Application number: 2024/90620	
What is the application for?:	Erection of rear extension and front and rear dormer extensions (within a Conser
Address of the site or building:	5A, Greenway, Honley, Holmfirth, HD9 6NQ
Postcode:	HD9 6NQ

### User comments

Rear Elevation S
1 : 100

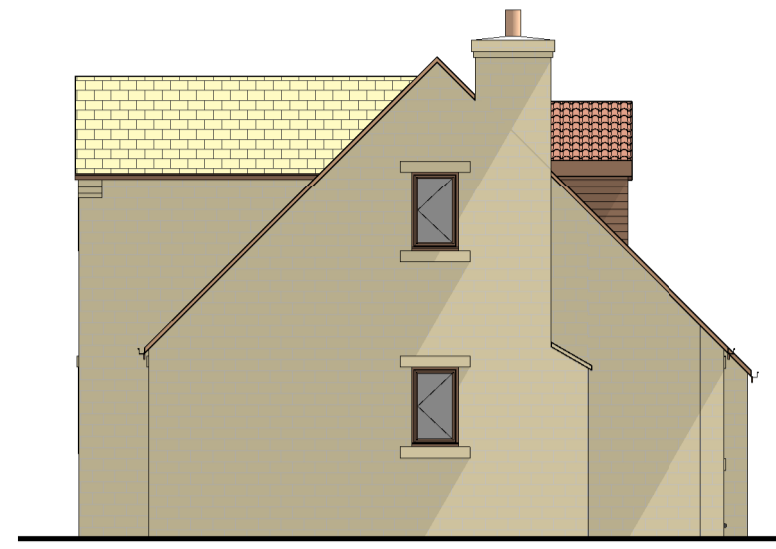
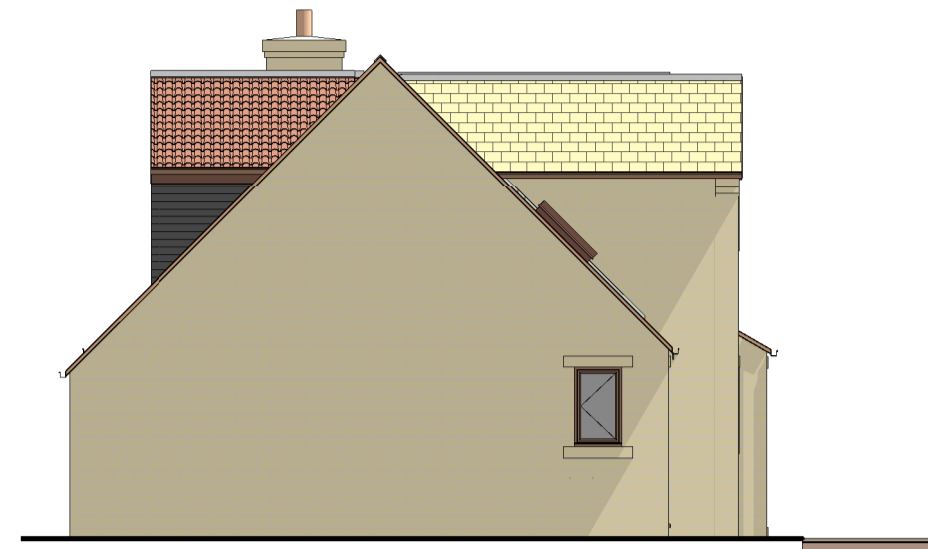
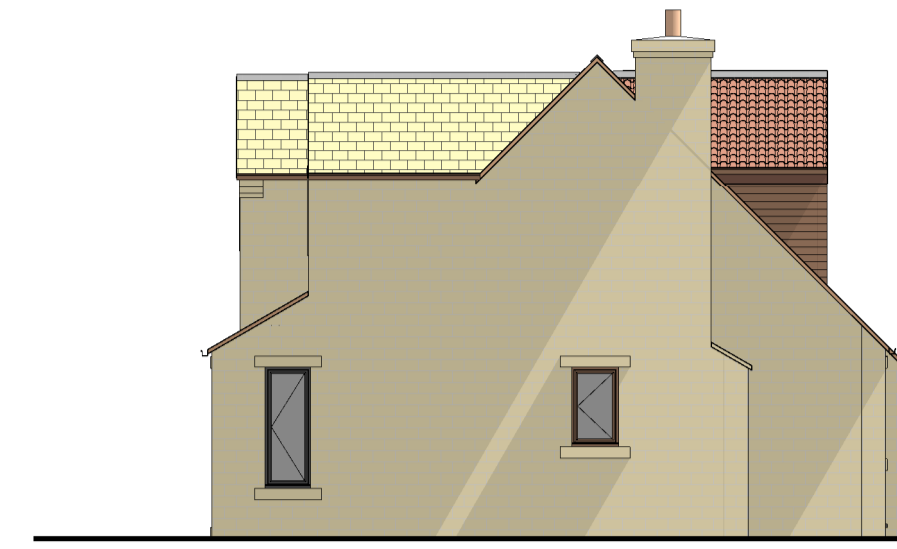
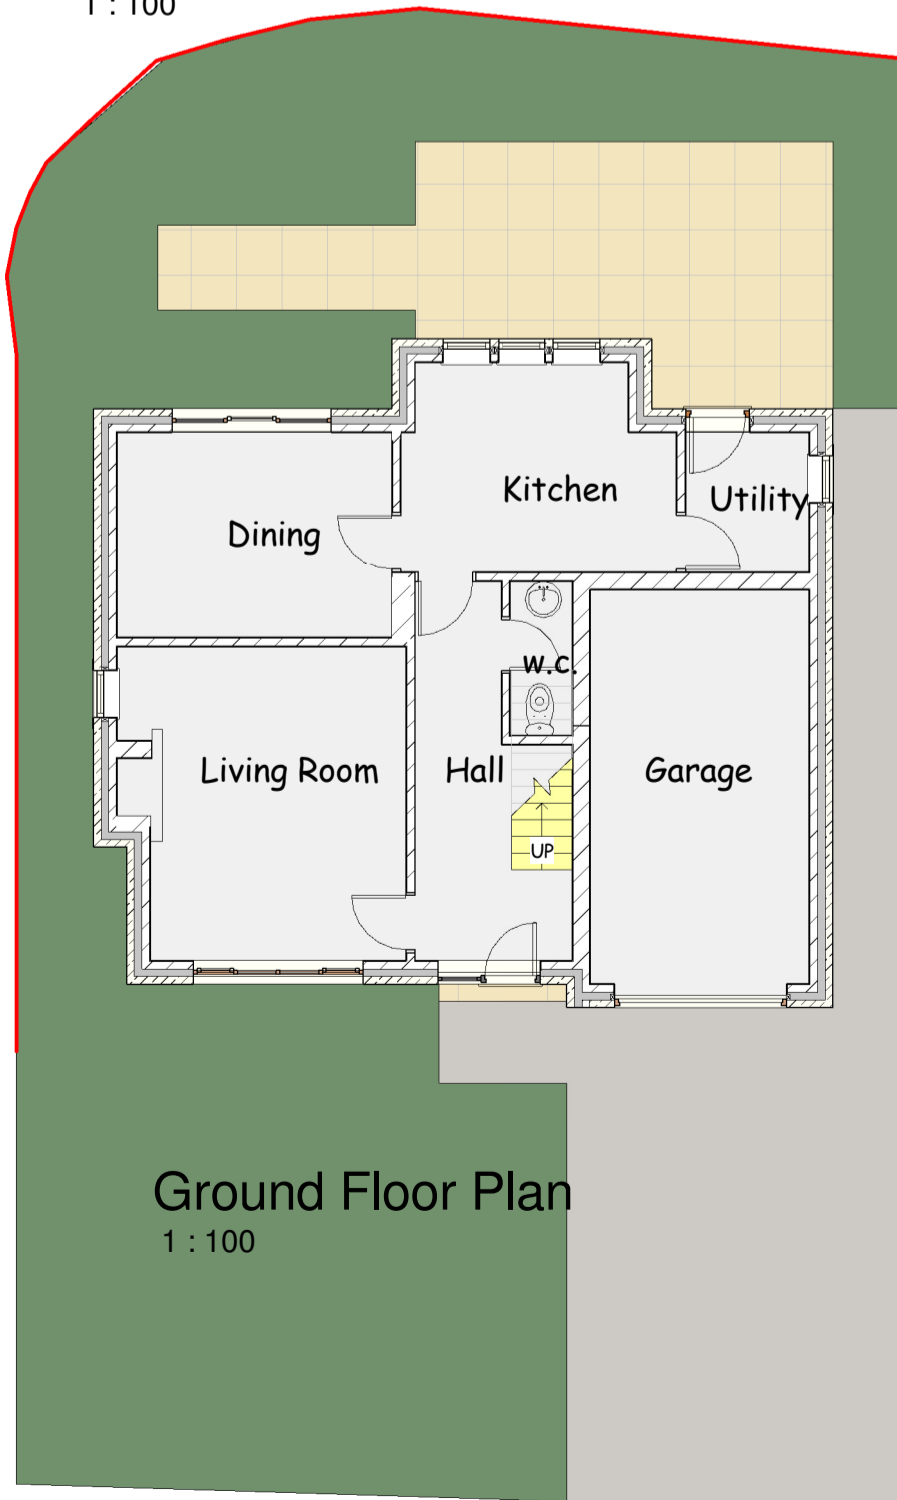
“The proposed rear extension would represent an addition to the rear of the dwelling which would create a feeling of overdevelopment within the site. With positioning of the dwelling at the front of a cul-de-sac, the extension would be an out of character addition to the street-scene. Whilst there is a boundary hedge which would screen a single storey extension, the single storey extension would be visible from the pathway and other sections of the cul-de-sac. It is considered that the development would result in development which is not fully compliant with the SPD and there is no justification which would overcome the visually harmful impact of the proposal in this regard. This element of the proposal is therefore considered to be unacceptable.”

This is a reinforcement of the previous point, and the current proposals have not changed to an extent that a different conclusion should be drawn.

First Floor Plan
1 : 100

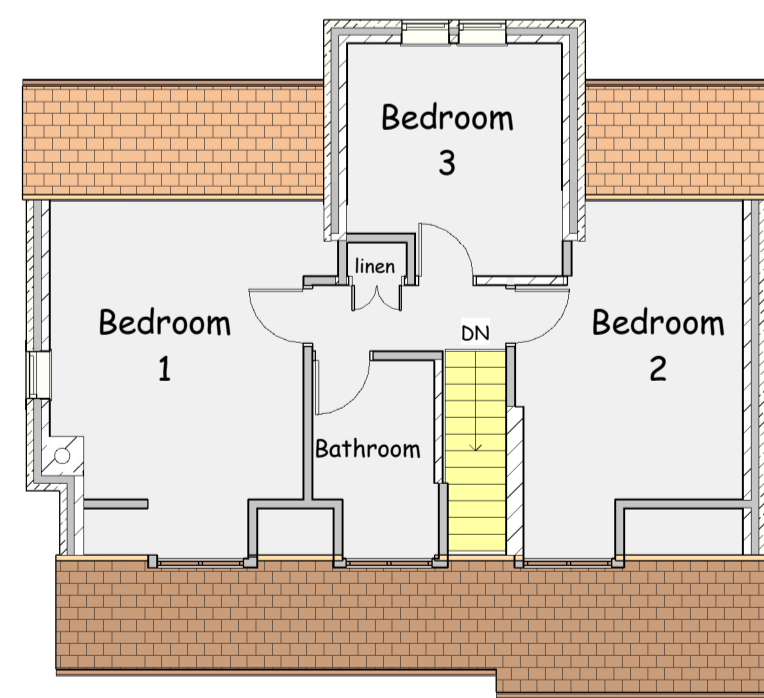
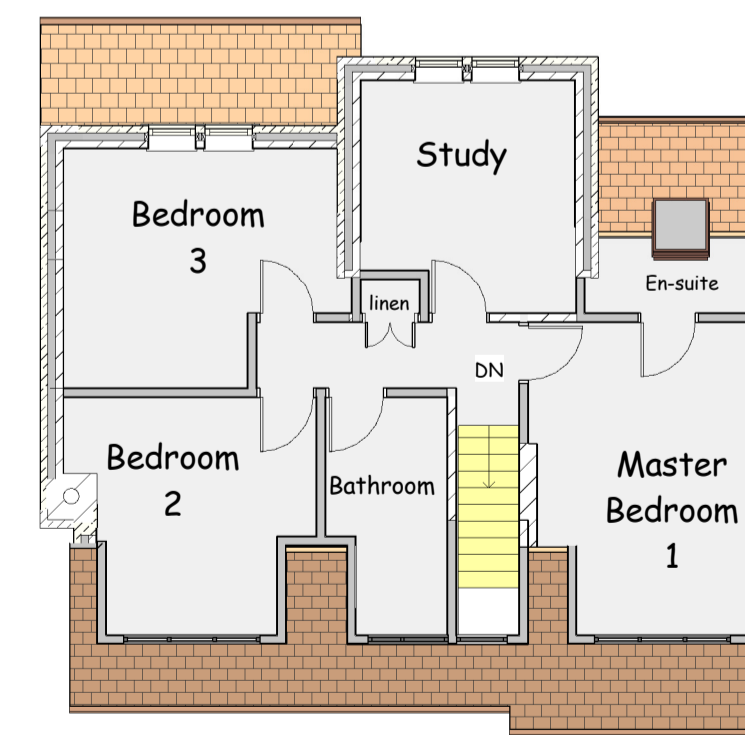
The first point to make in relation to the new proposal is that it is for the creation of a four bedroomed property. Although the drawings label one of the bedrooms a ‘study’, the application itself states that the proposal would create four bedrooms. As such it needs to provide parking space for at least 3 vehicles. Whilst respecting the conclusions of the Planning Officer in relation to the previous proposal, I believe the parking situation has changed in this part of the village over the last 12 months, and is likely to change further in the future. As such, I believe this aspect of the decision merits reconsideration.
